Final Drainage Report

Amendment No. 1

Beacon Lite Road Stockpile

EDARP File No. CDR261

D4
sheet number

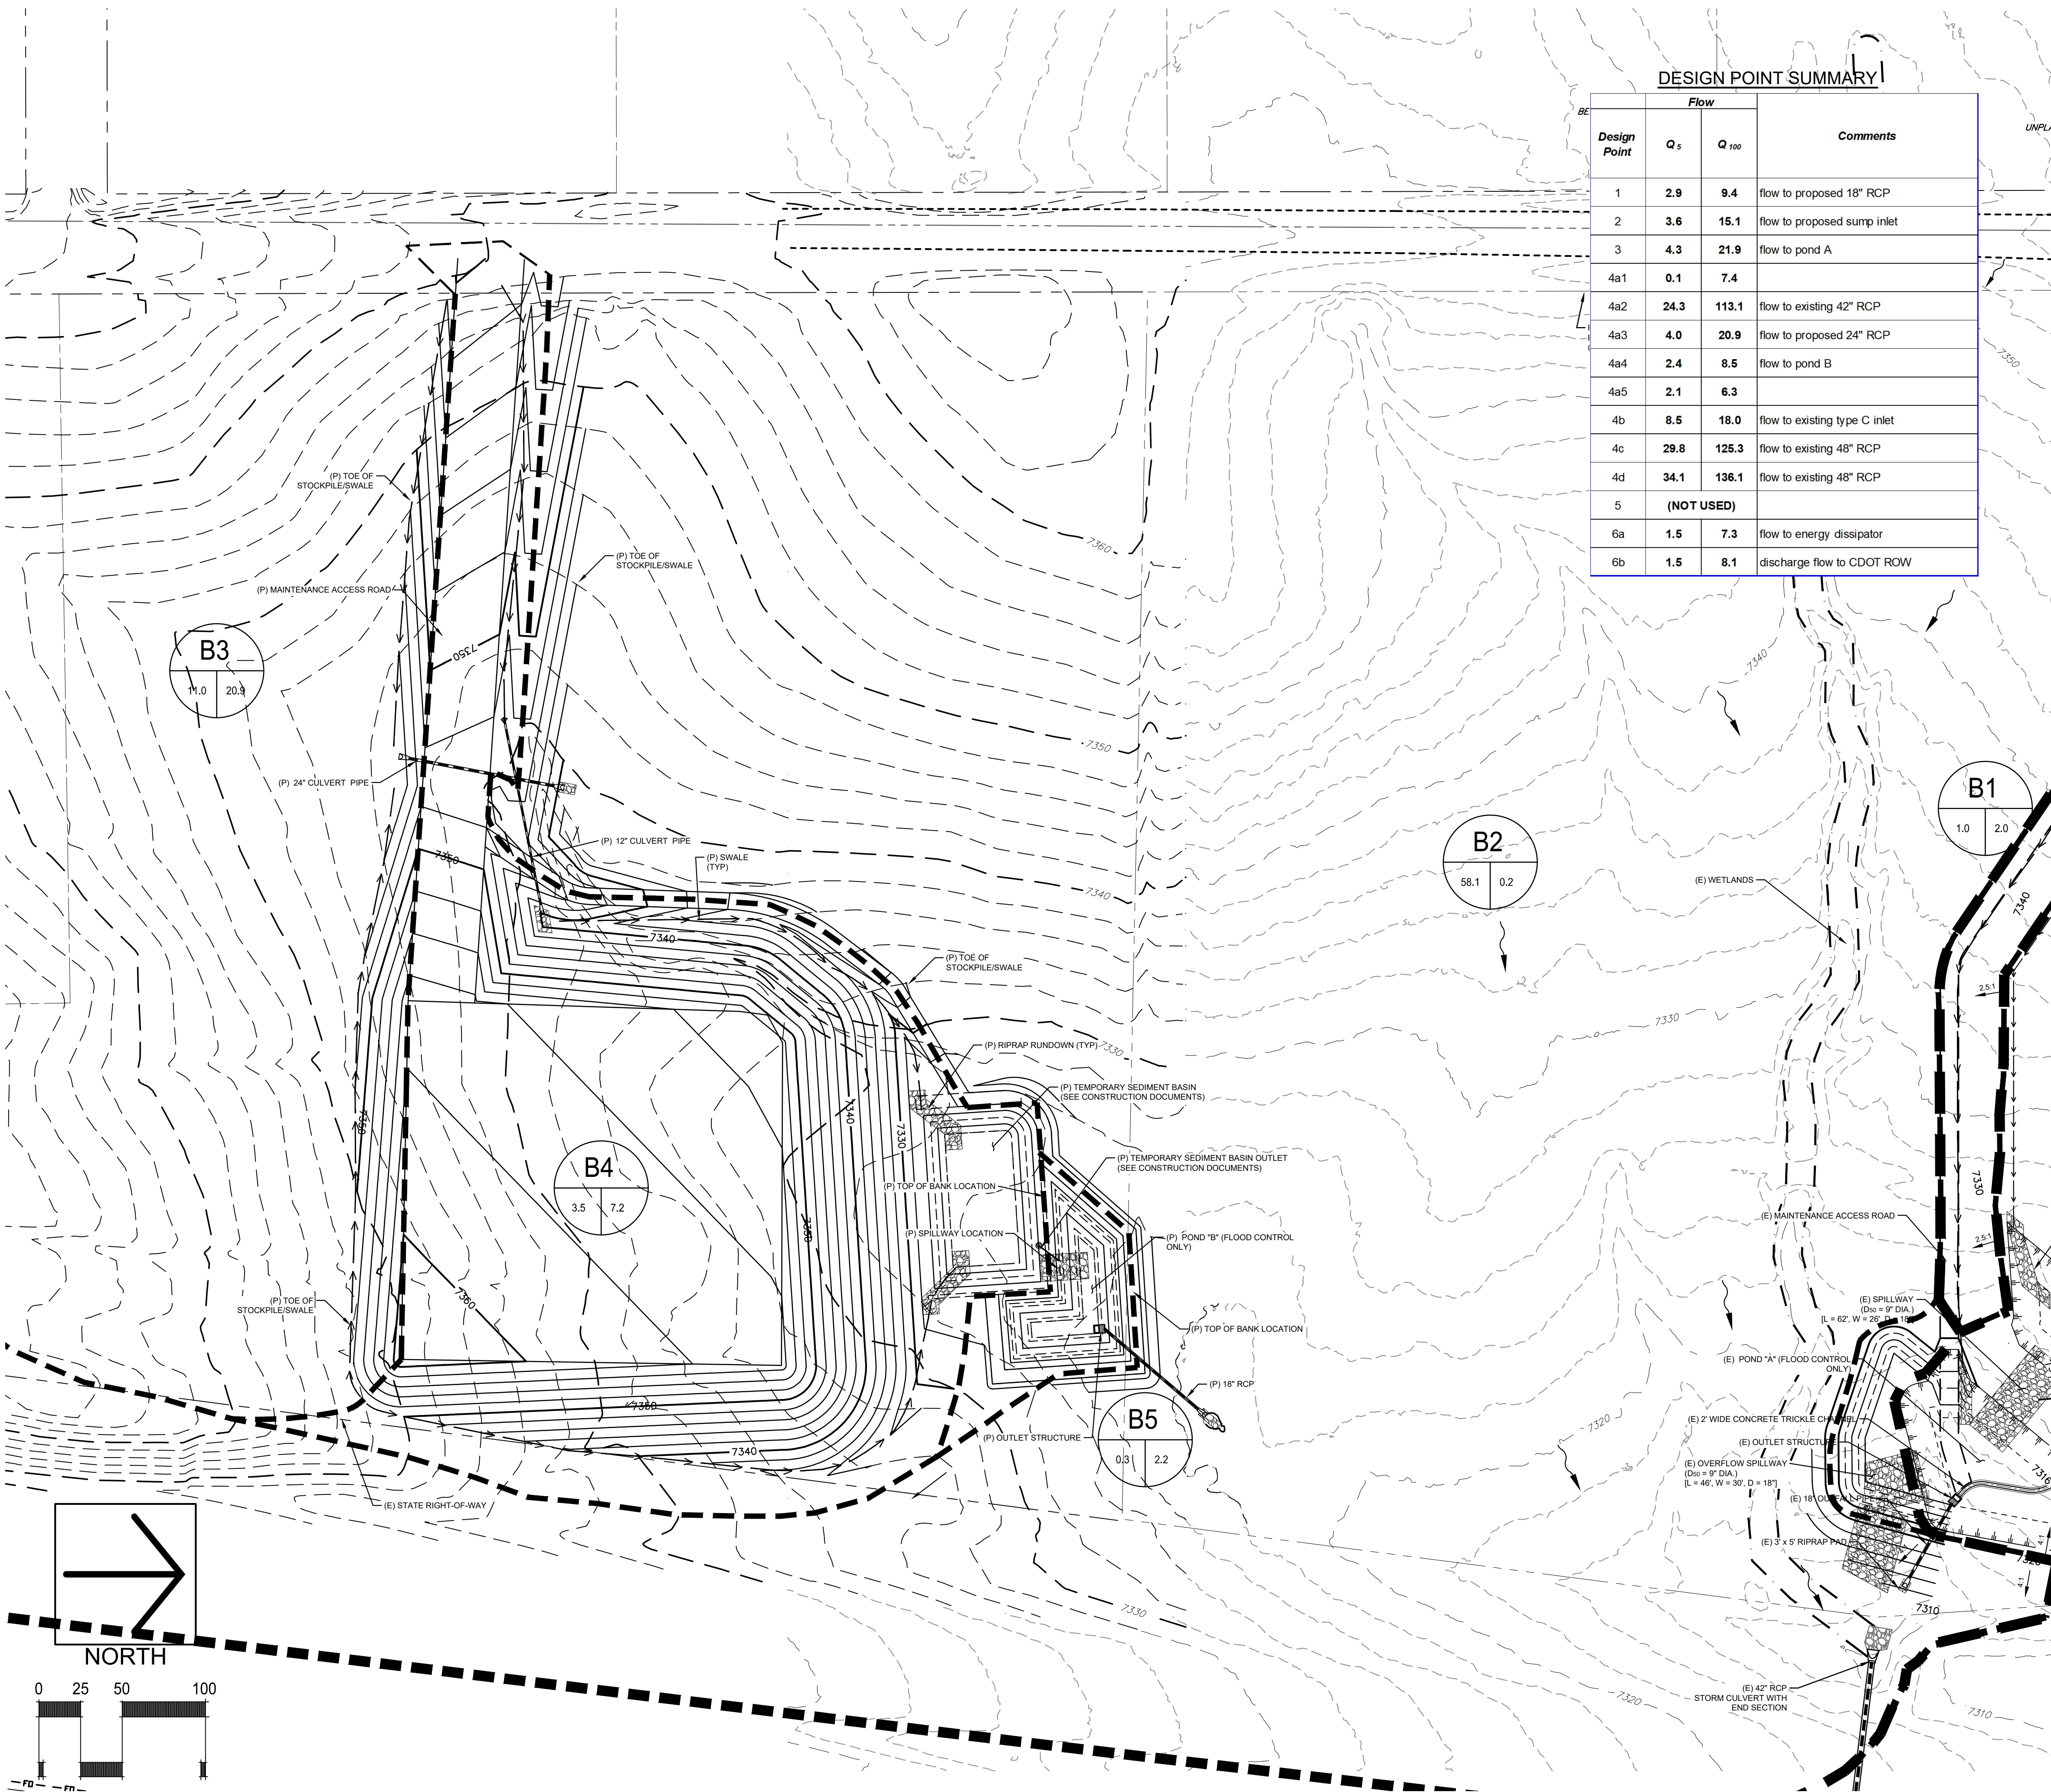
proposed contours are not shown. Please provide.

label on the drainage map

DRAINAGE PLAN:
PROPOSED CONDITIONS - SITE (SOUTH)

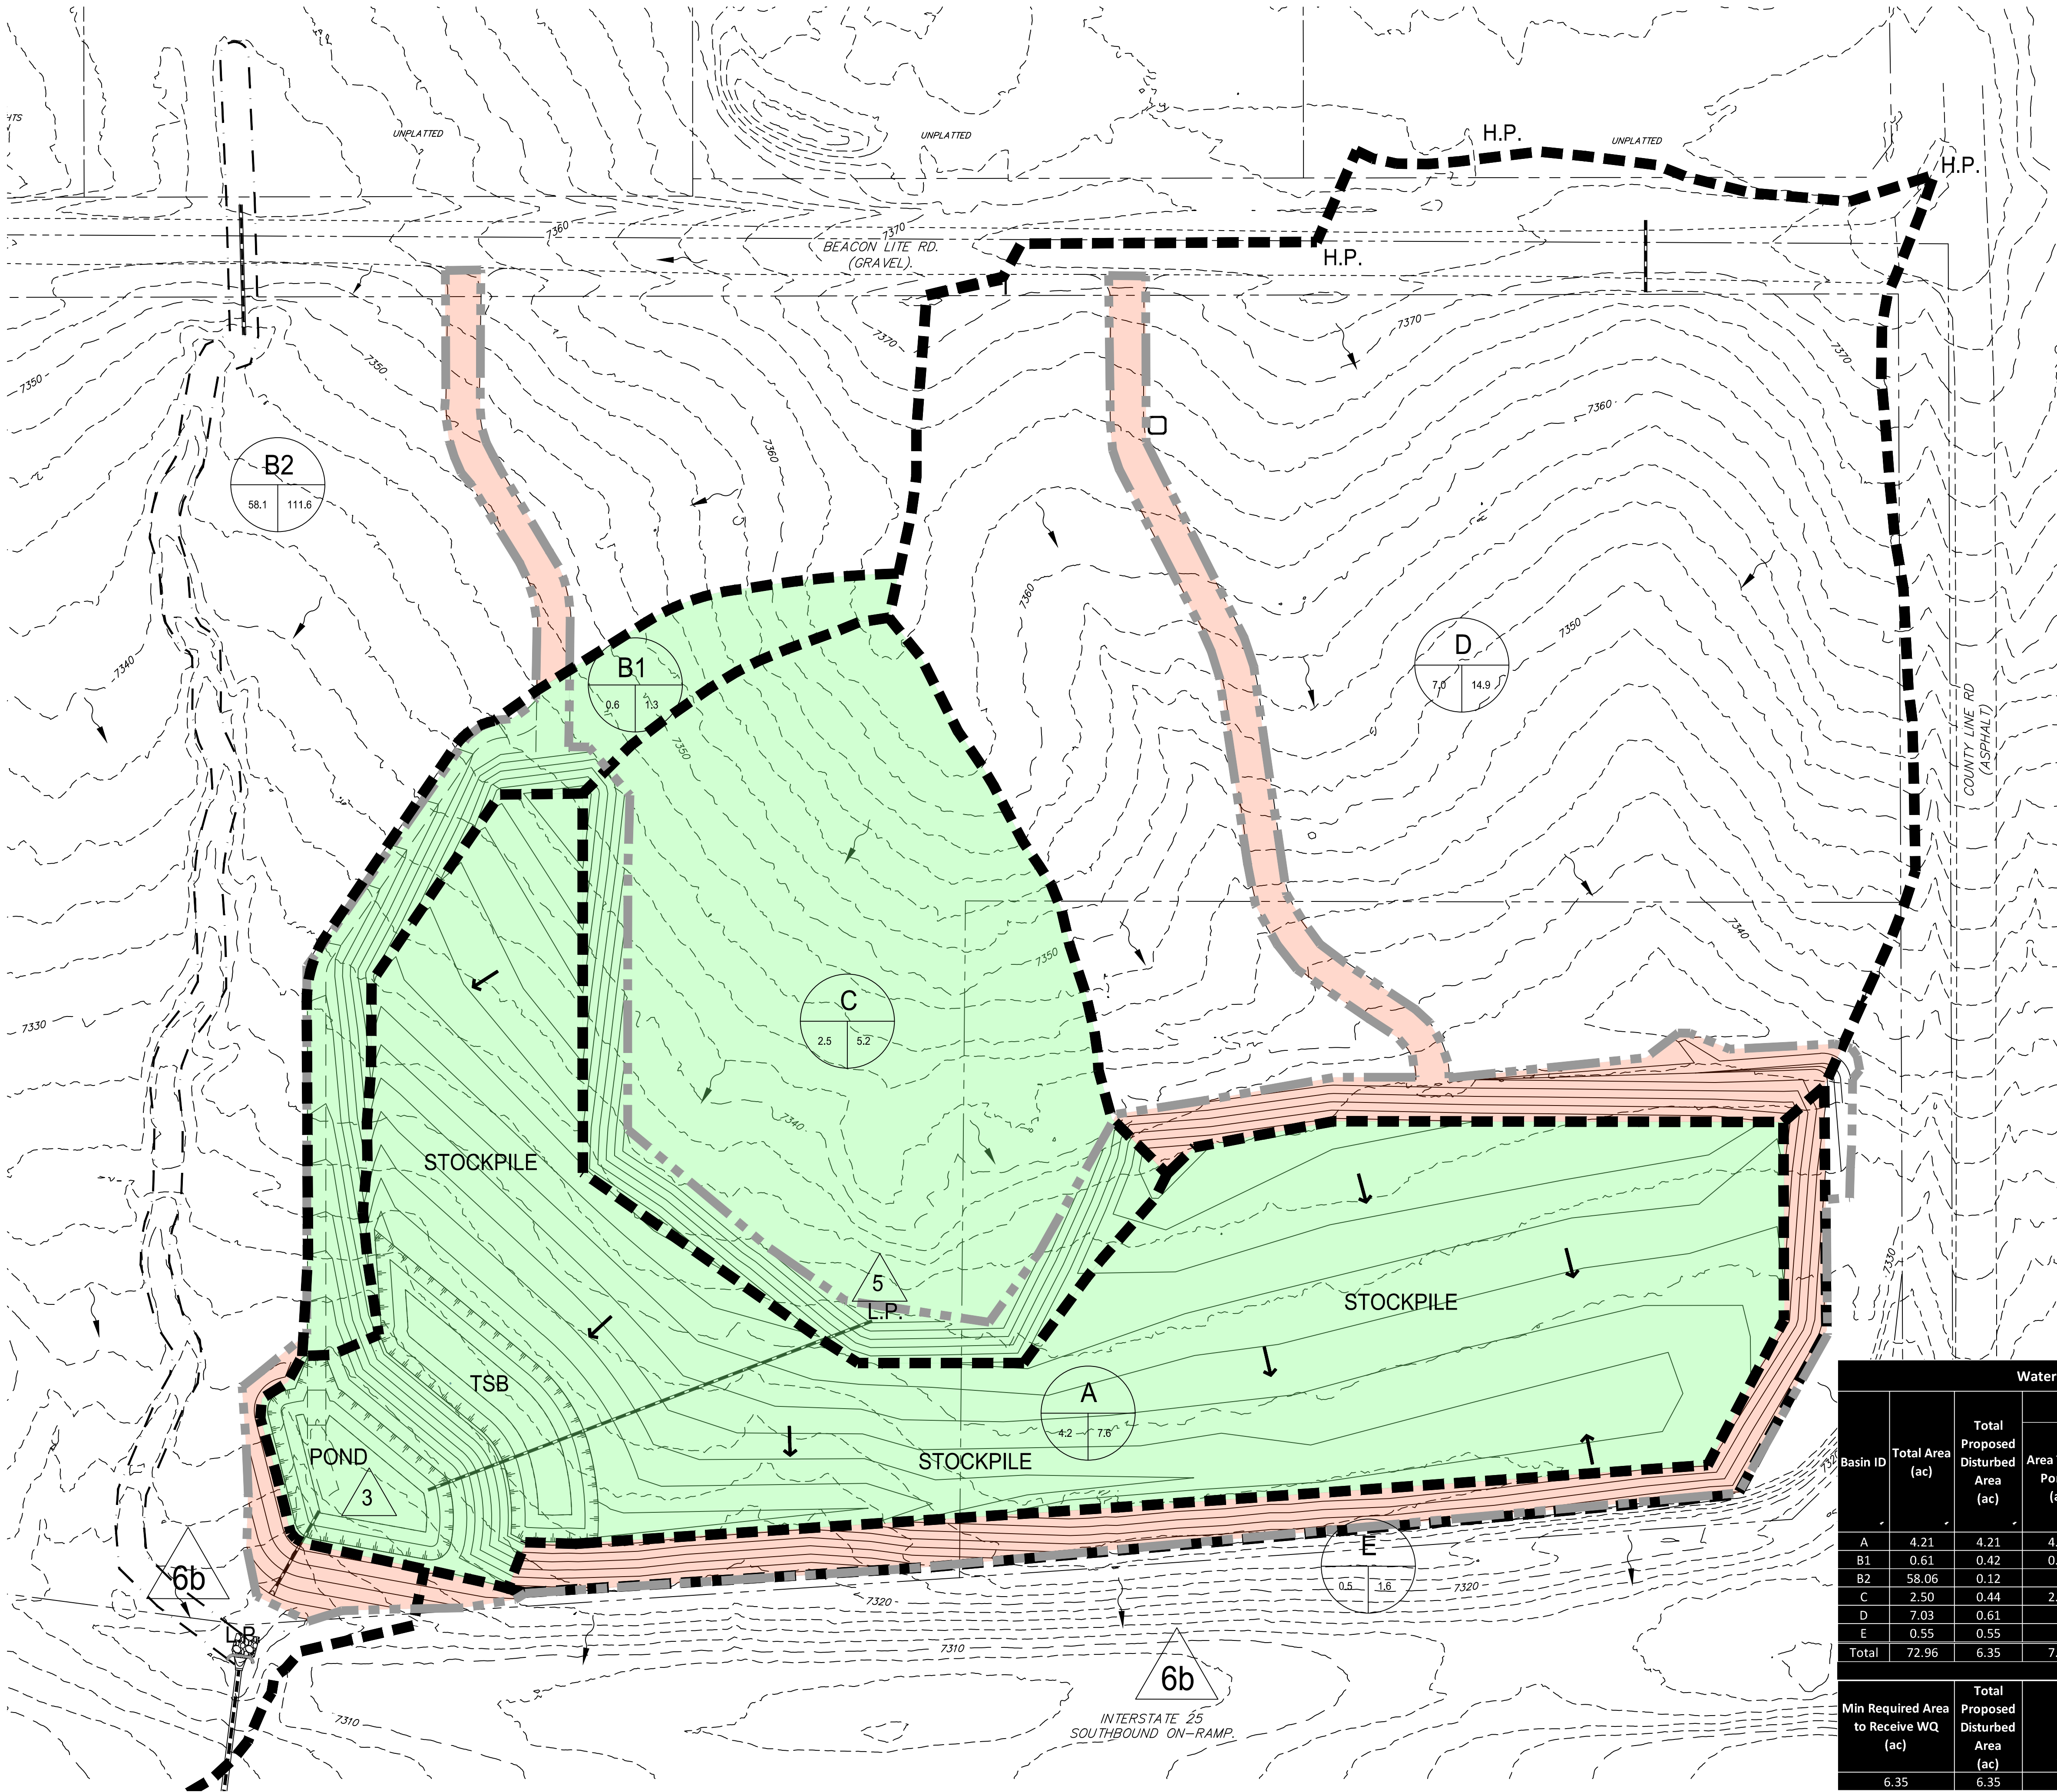
C2 is new fill area that is proposed over the existing forested land. Please revise.

C1 and C2 are conveyed by pipe to the new TSB and then after overtopping will go to the pipe that leads to pond A (Design point 3)
